June 18, 2015

**RE: Skilled Nursing Facility, 1610 Renaissance Blvd NE  
Grading and Drainage Plan  
Engineer's Stamp Date 5-21-2015 (File: F16-D017)**

Based upon the information provided in your submittal received 5-22-15, the above referenced Grading Plan cannot be approved for DRB action on the Site Development Plan for Building Permit until the following comments are addressed:

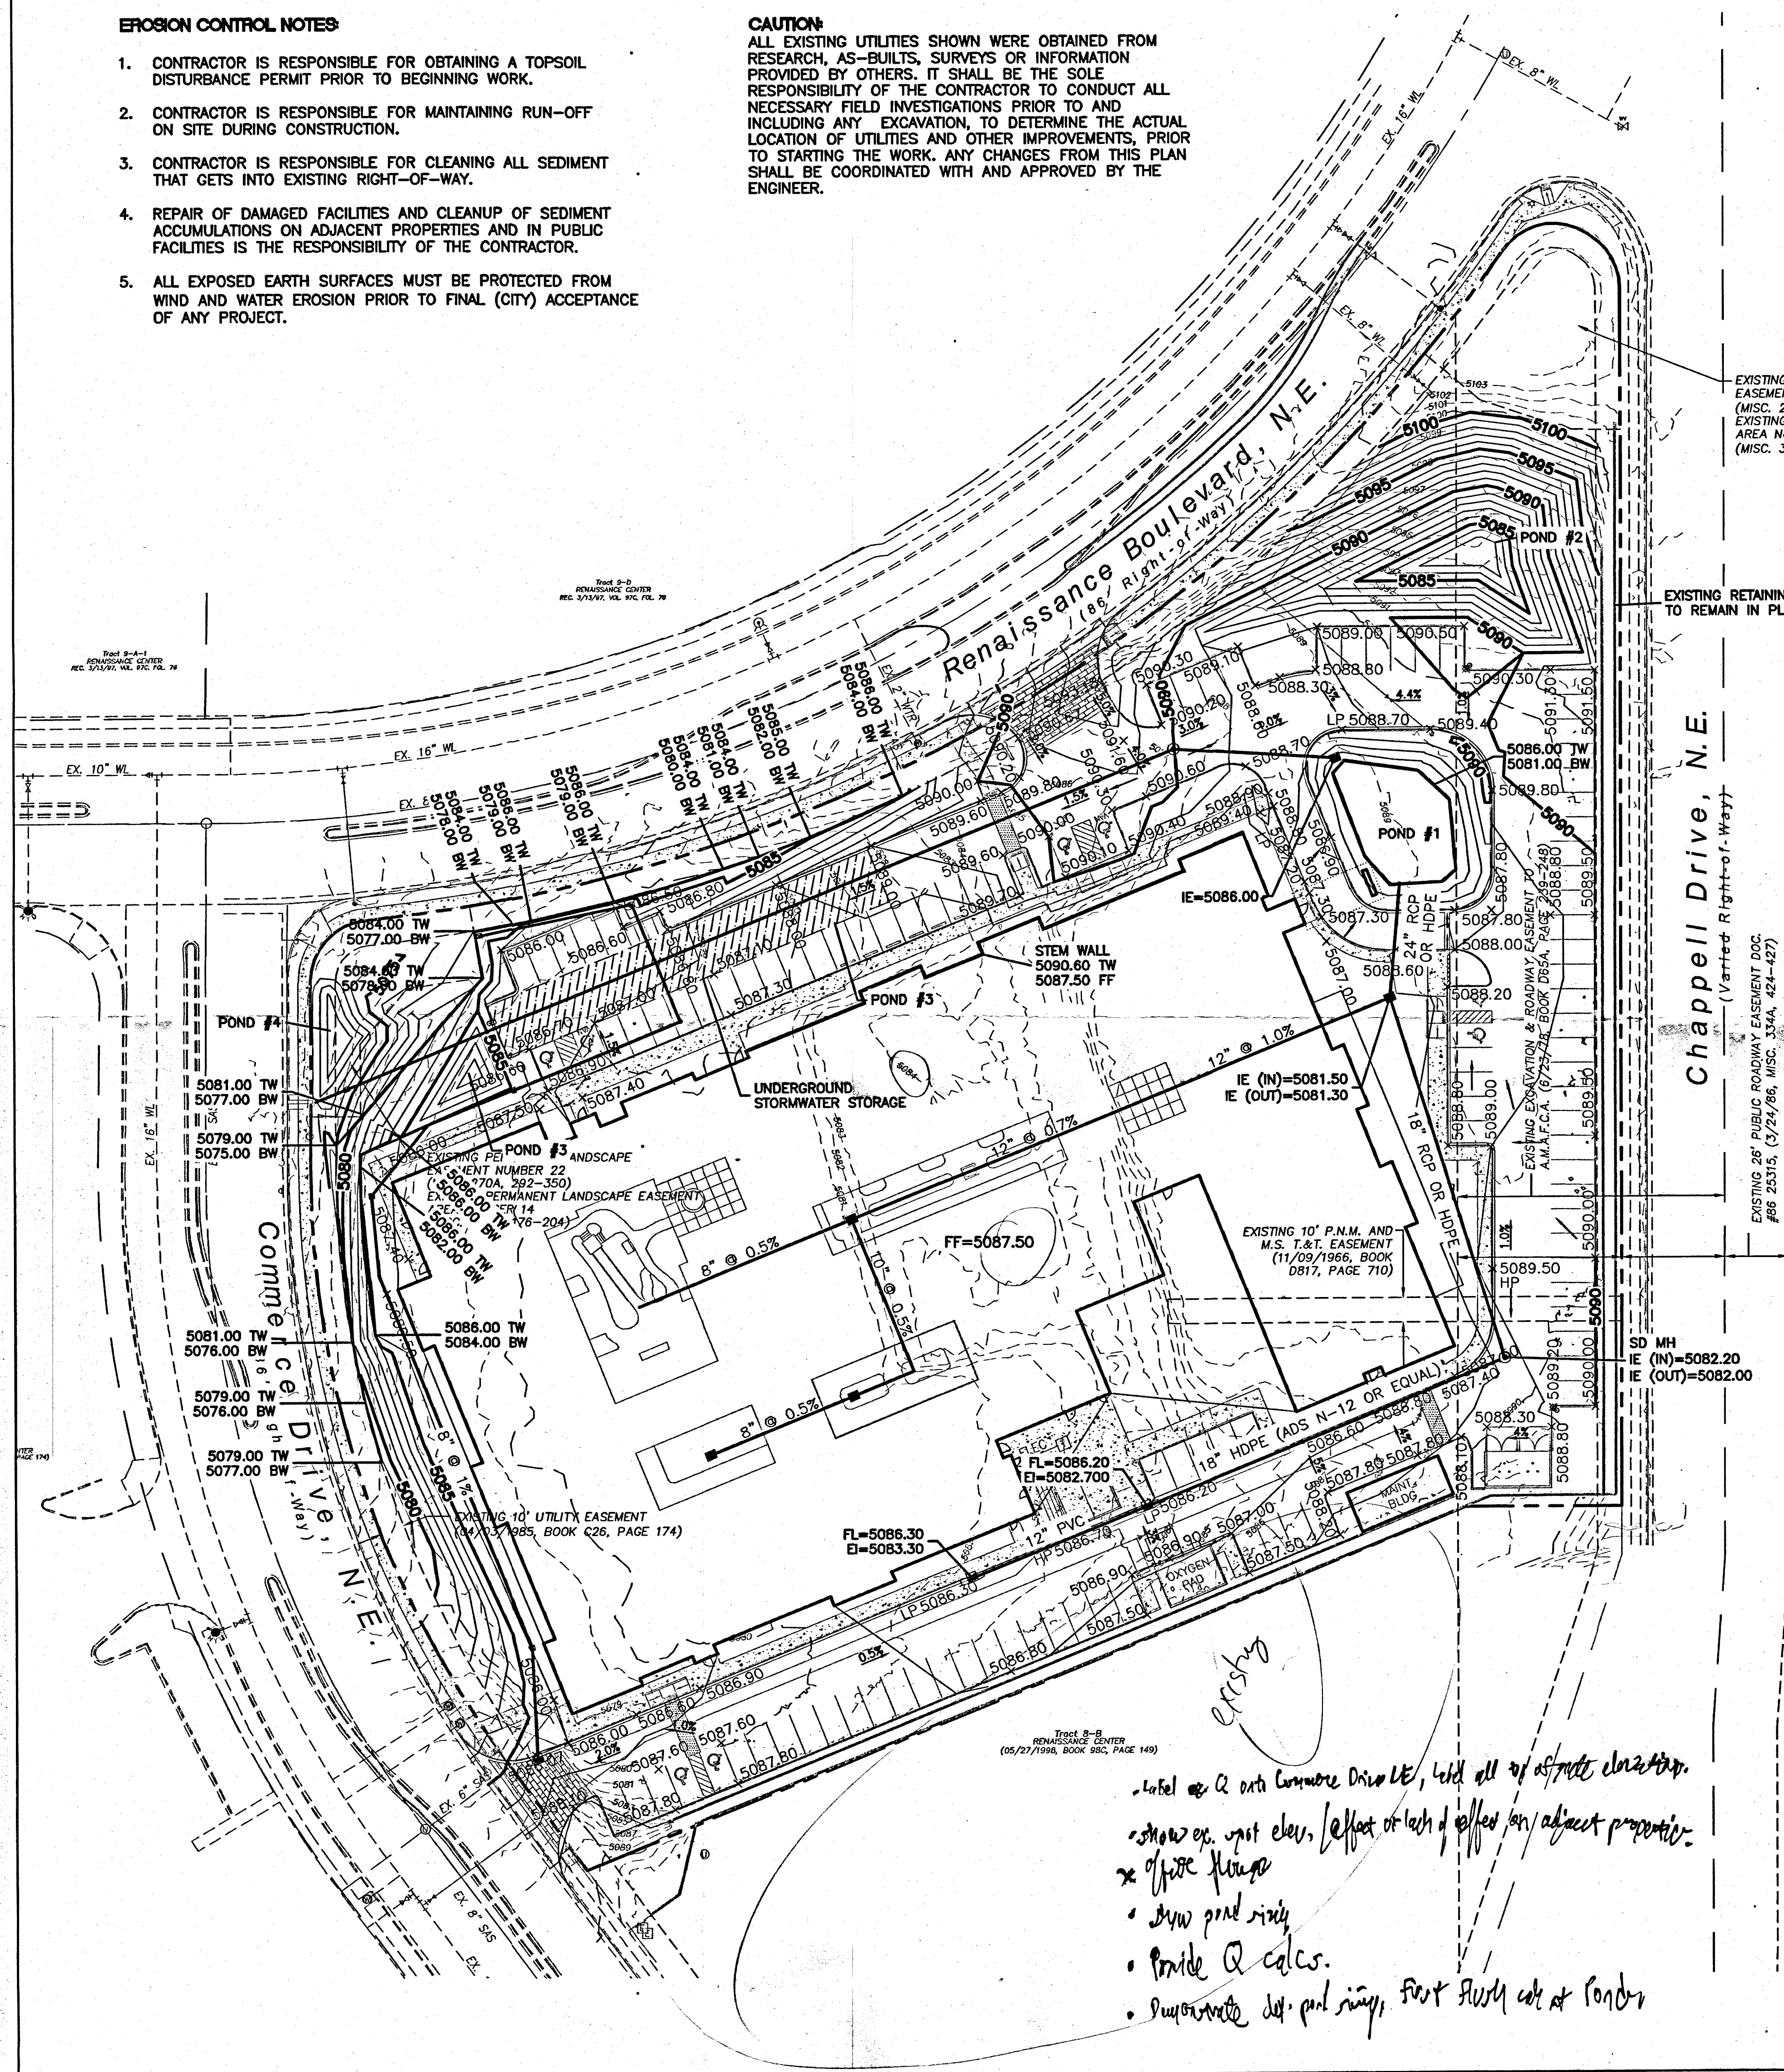
- 1) Provide 100-year storm flow computations for existing and proposed conditions. Show basin boundaries. Also provide first flush computations.
- 2) Demonstrate that the site is discharging the allowable flow per the "Renaissance Drainage Master Plan". Label the existing sidewalk culvert on Commerce Drive, culvert size, and flow discharge onto Commerce Drive. Show existing flowline elevation at the outlet of the existing culvert.

- 3) Label existing spot elevations around the perimeter of the site to show relationship of new grades to existing surrounding grades. Indicate that the grading of the site does not adversely impact the property to the south.

- 4) Label pond sizes along with first flush volumes within each pond. Demonstrate that they meet requirements for proposed detention or retention of storm flow.

- 5) Label all proposed storm drain sizes, top of grate elevations, and flow that the storm drain is conveying. Show which way the roof is draining.
- 6) Call out curb cuts as applicable on the east side of the site if the parking lot is draining to Pond 1.

- 7) There is concern about the location of the inlet shown on the upstream side of a wall labeled for Pond 1 (IE=5086.00). Was it meant to place this inlet in the bottom of Pond 1 for detention purposes?
